KRISTEN ESTATES FINAL PLAT CONSTRUCTION DOCUMENTS

EPC STORMWATER REVIEW COMMENTS
IN ORANGE BOXES WITH BLACK TEXT

KRISTEN ESTATES
EL PASO COUNTY, COLORADO
CONSTRUCTION DOCUMENTS
COVER SHEET

KRISTIN ESTATES FINAL PLAT
EL PASO COUNTY, COLORADO
CONSTRUCTION DOCUMENTS
FIRE CISTERN

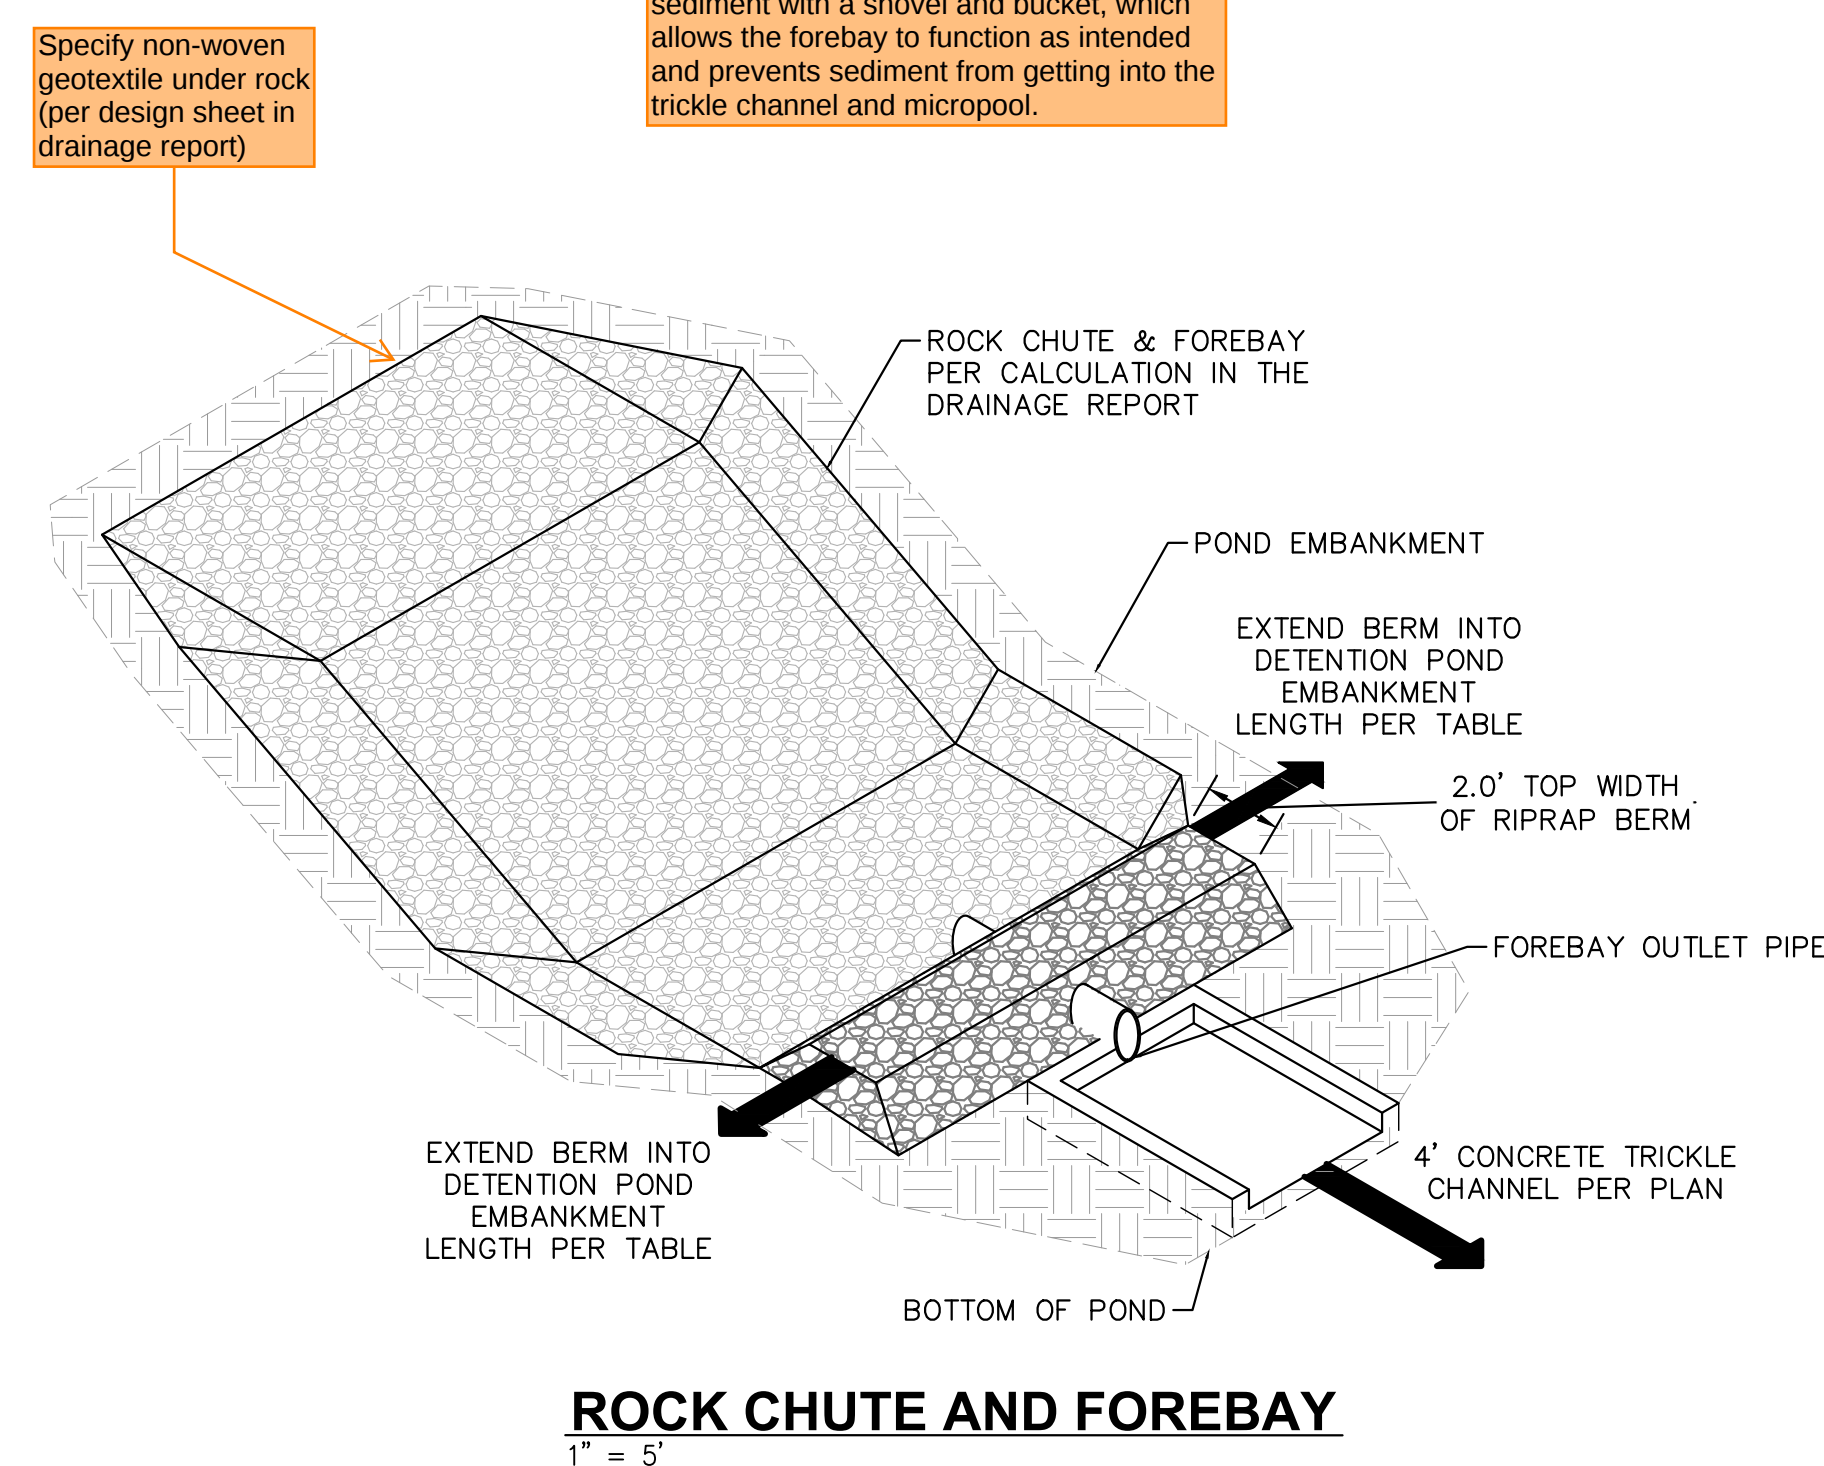
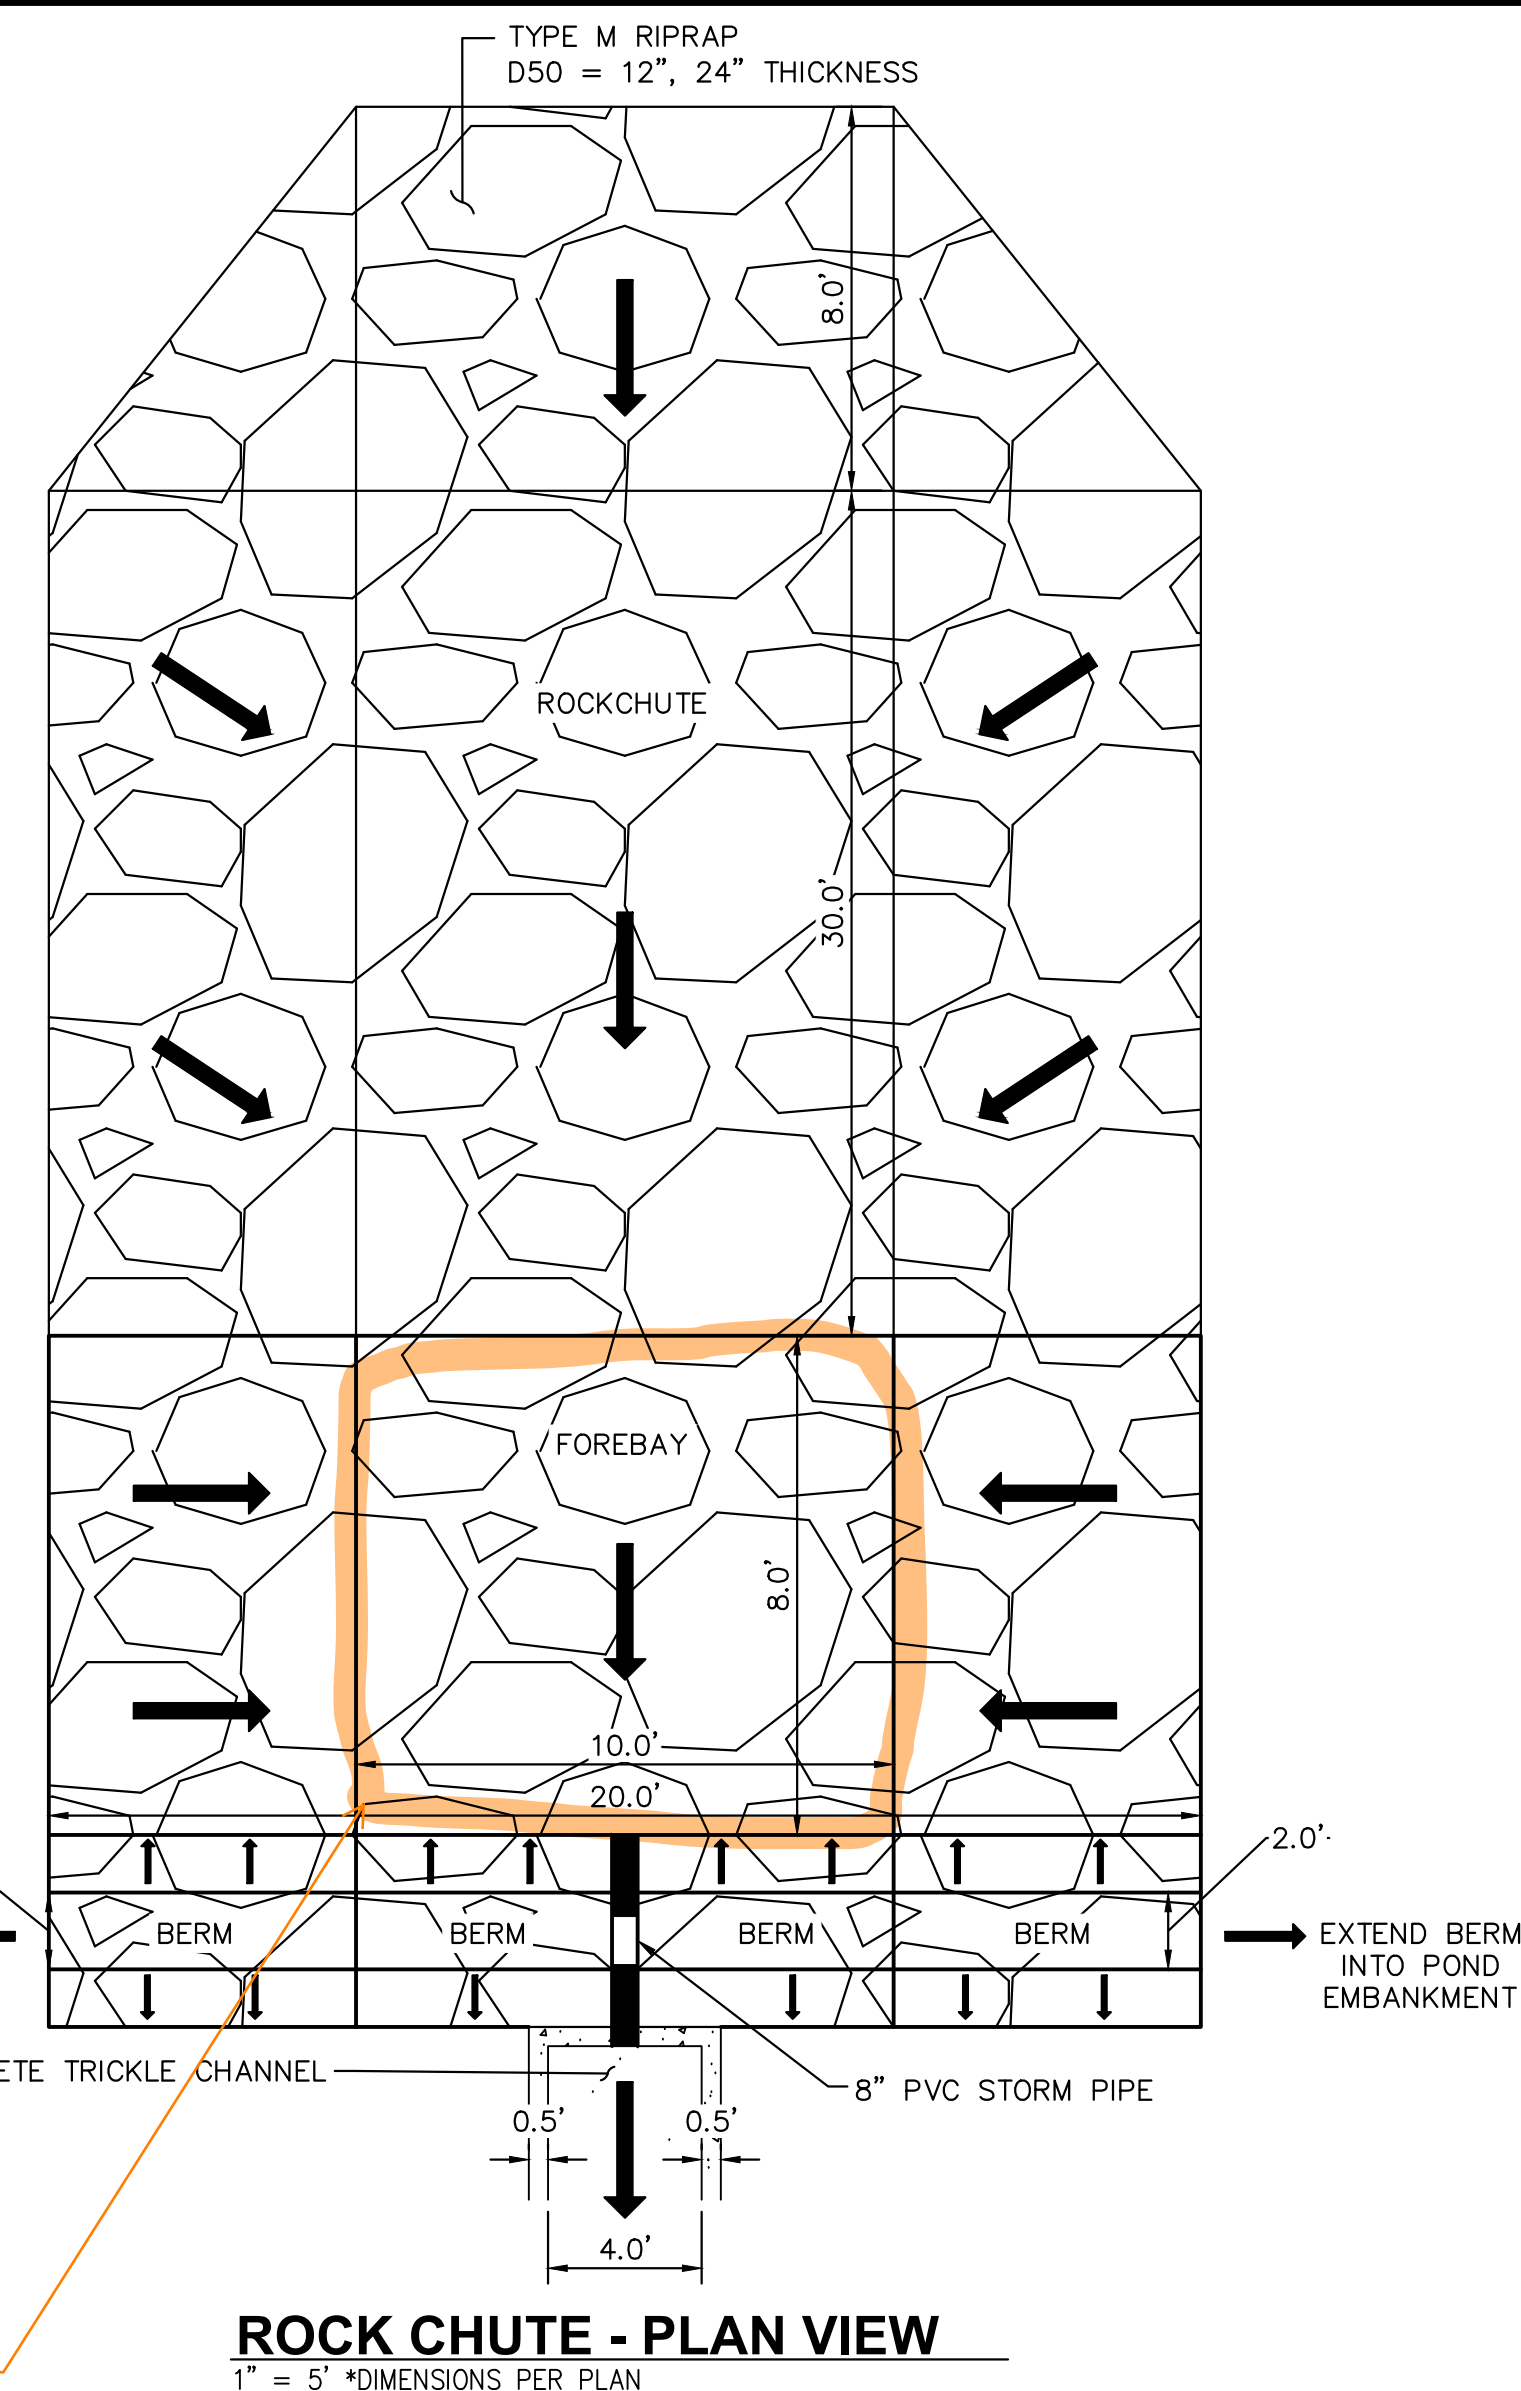
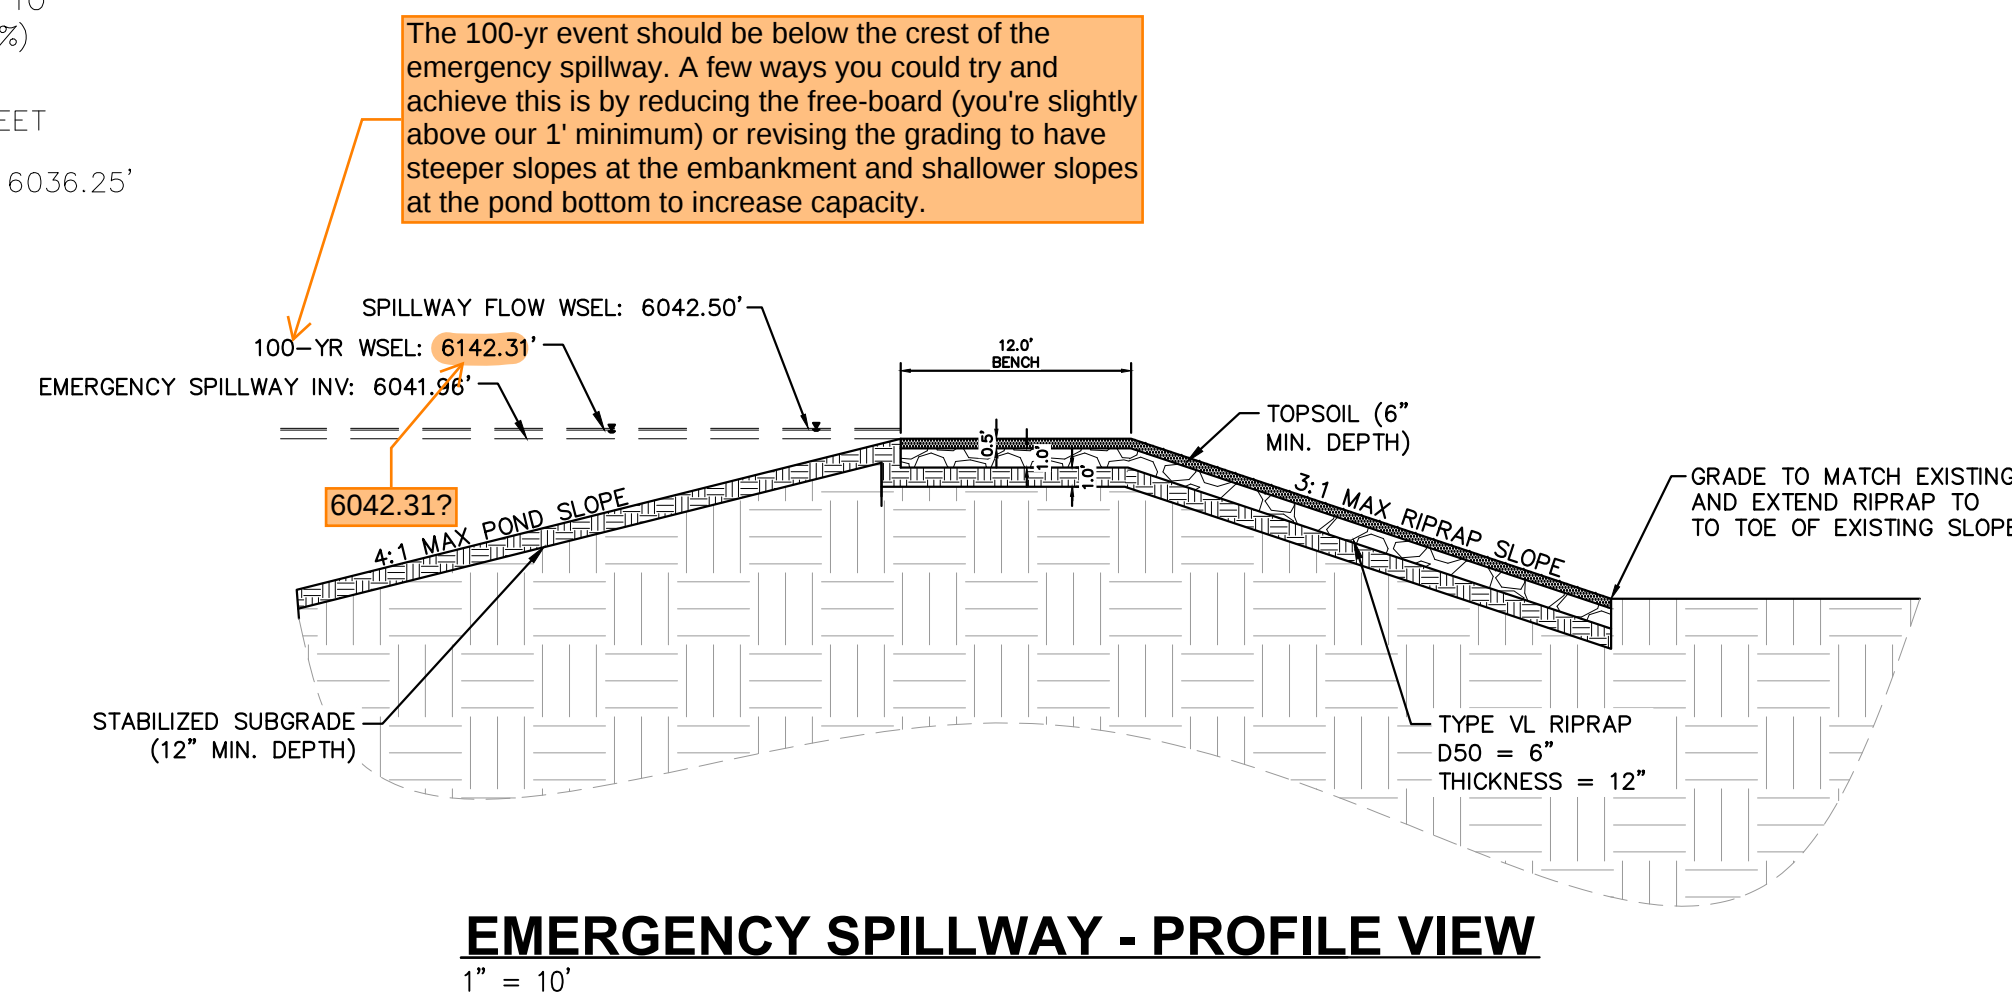
Provide the location of the cistern and the required turn out a dry hydrant.
